From: Gradwell Michael <Michael.Gradwell@networkrail.co.uk> on behalf of TownPlanning LNW <TownPlanningLNW@networkrail.co.uk>
Sent: 25 October 2018 17:00
To: planning
Cc: Jane Tucker
Subject: RE: Consultation on planning application 3/2018/0913 land off Clitheroe Road, adjacent to Shaw House Farm, BB7 9AD

3/2018/0913

Land off Clitheroe Road, adjacent to Shaw House Farm, BB7 9AD
FAO Adam Birkett

The application is for the installation of a backup electrical generation hub together with security fencing, access, substations, gas kiosk and associated plant and equipment.

## SHAWHOUSE, WHALLEY - SITE LAYOUT

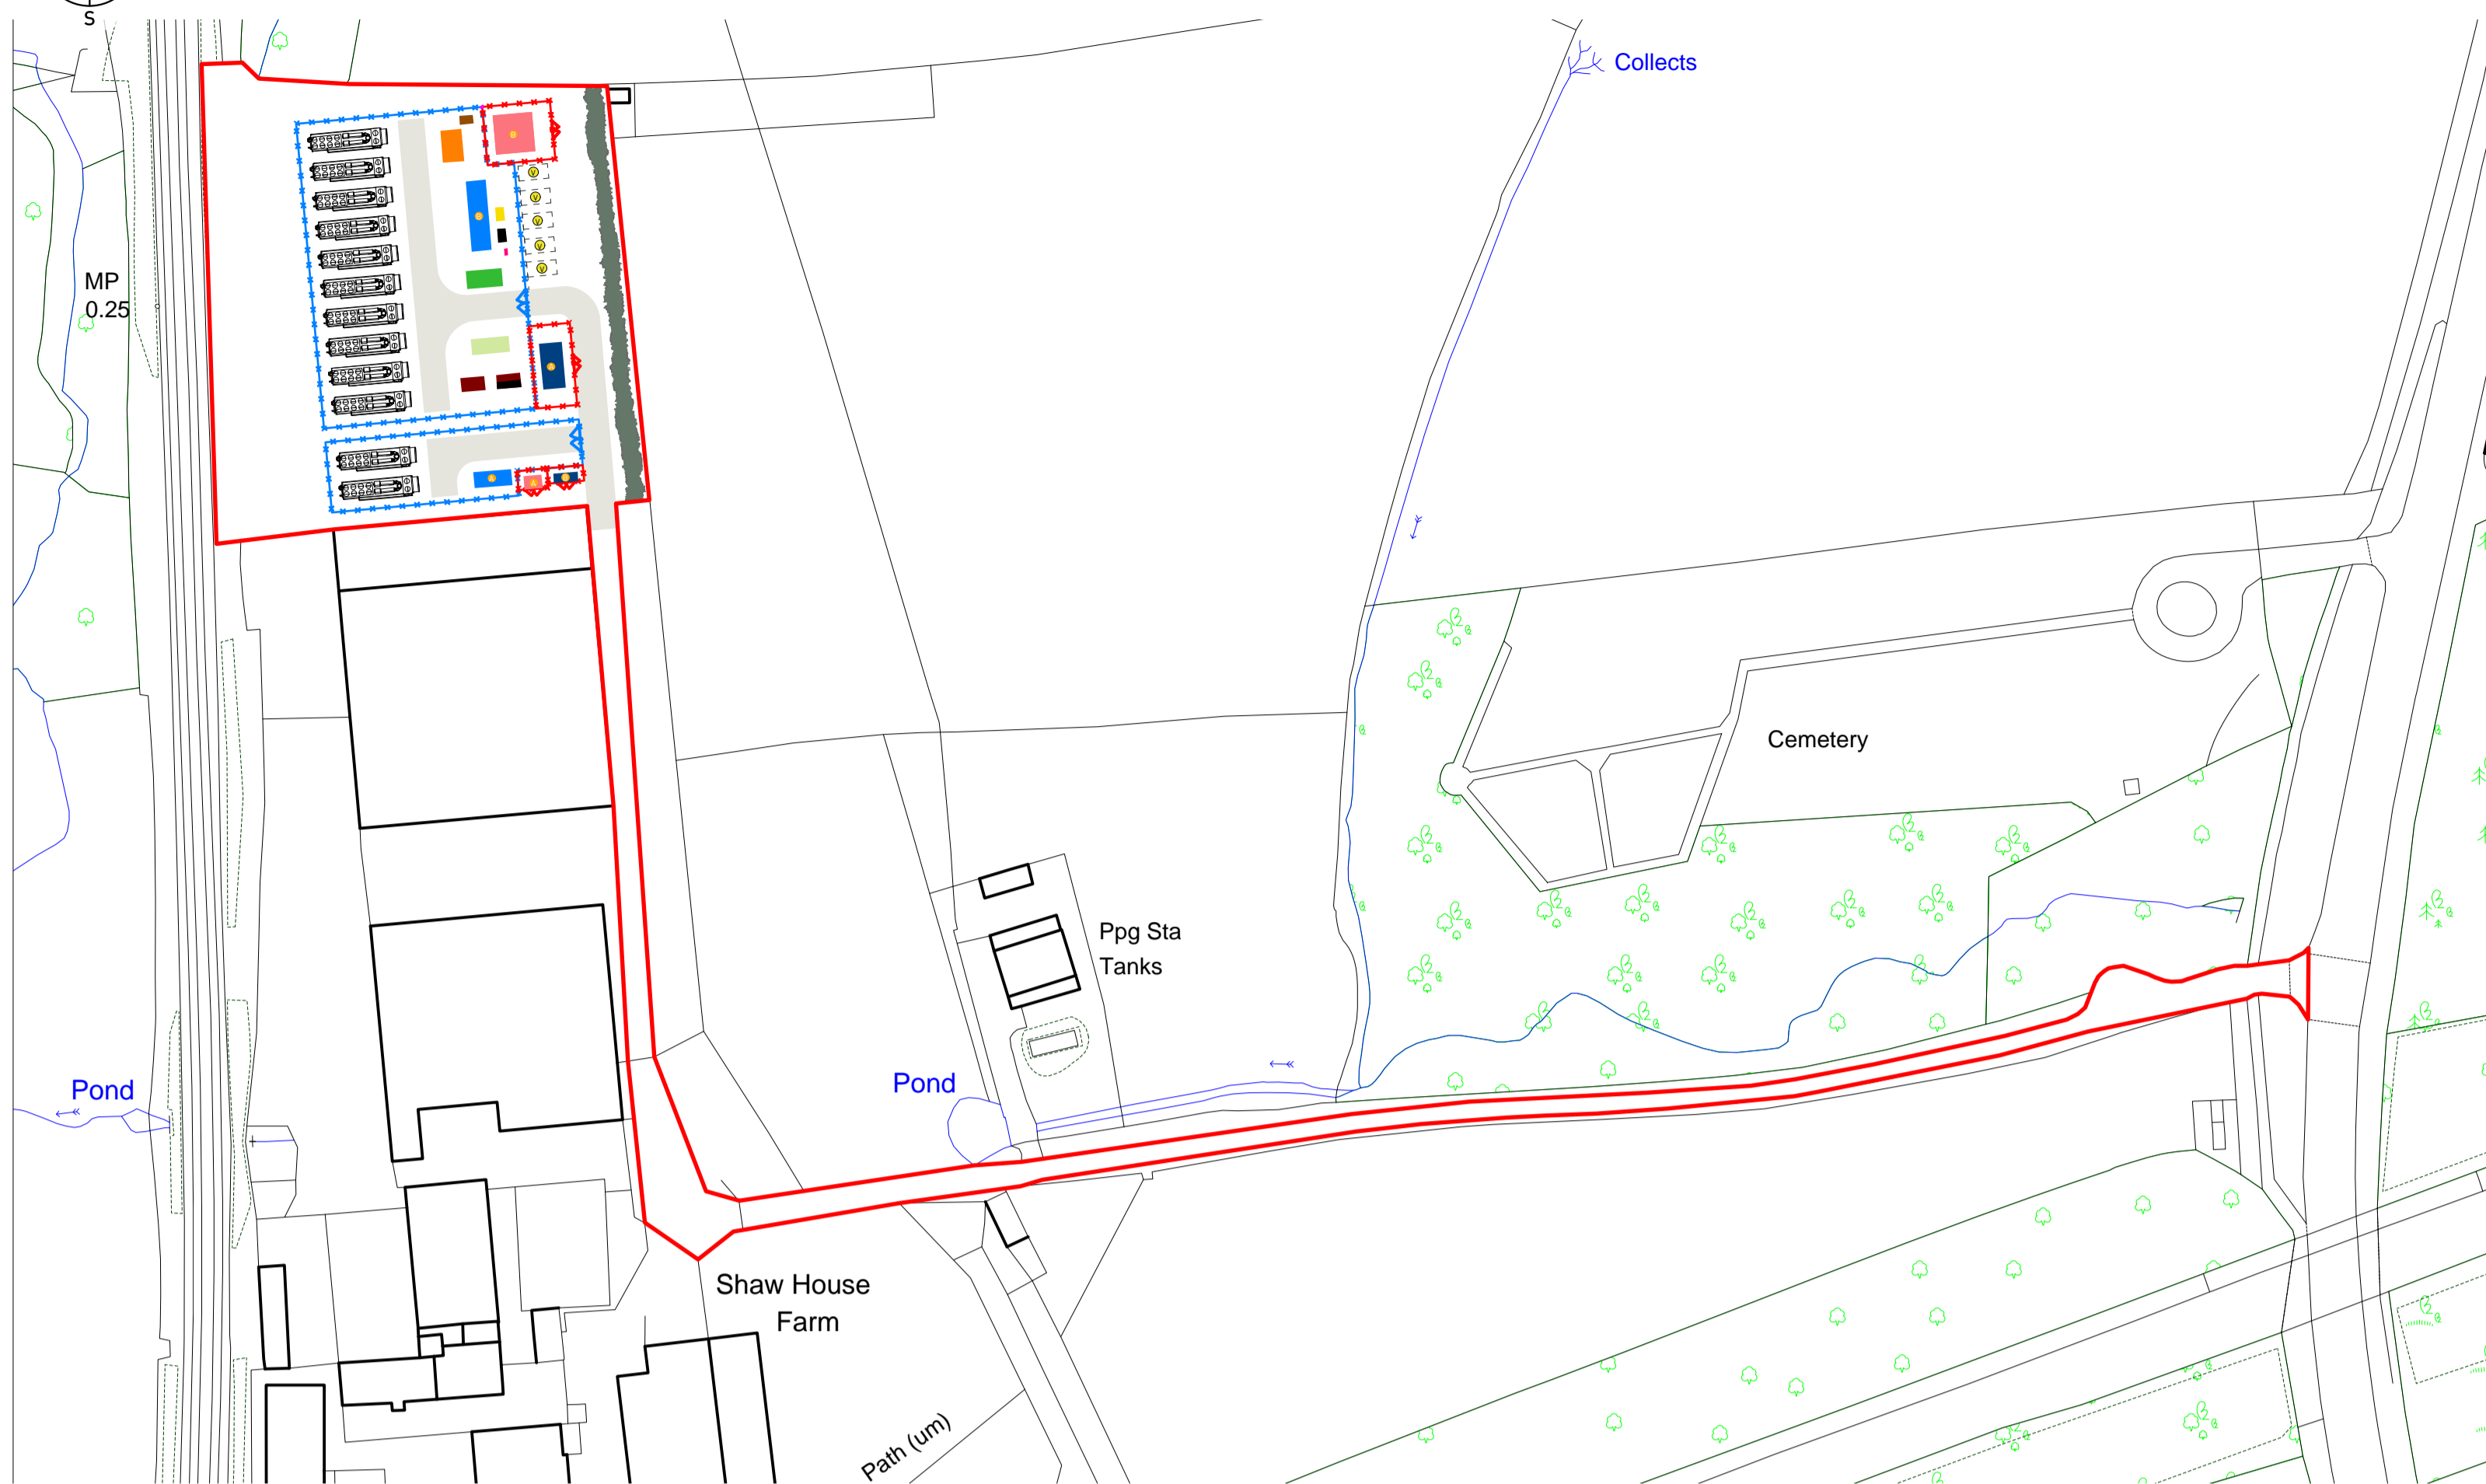
- Can Network Rail have sight of the significant findings from the site fire and DSEAR risk assessment documents.
- We require sight of an accurate depot layout plan showing the locations of any gas storage units, generators, fuel stores etc.

- Will the site be manned 24/7 by security personnel?
- Details of proposed transformer/substation locations (if applicable) to be submitted to Network Rail for acceptance due to risk of electro-magnetic interference with Signalling equipment.
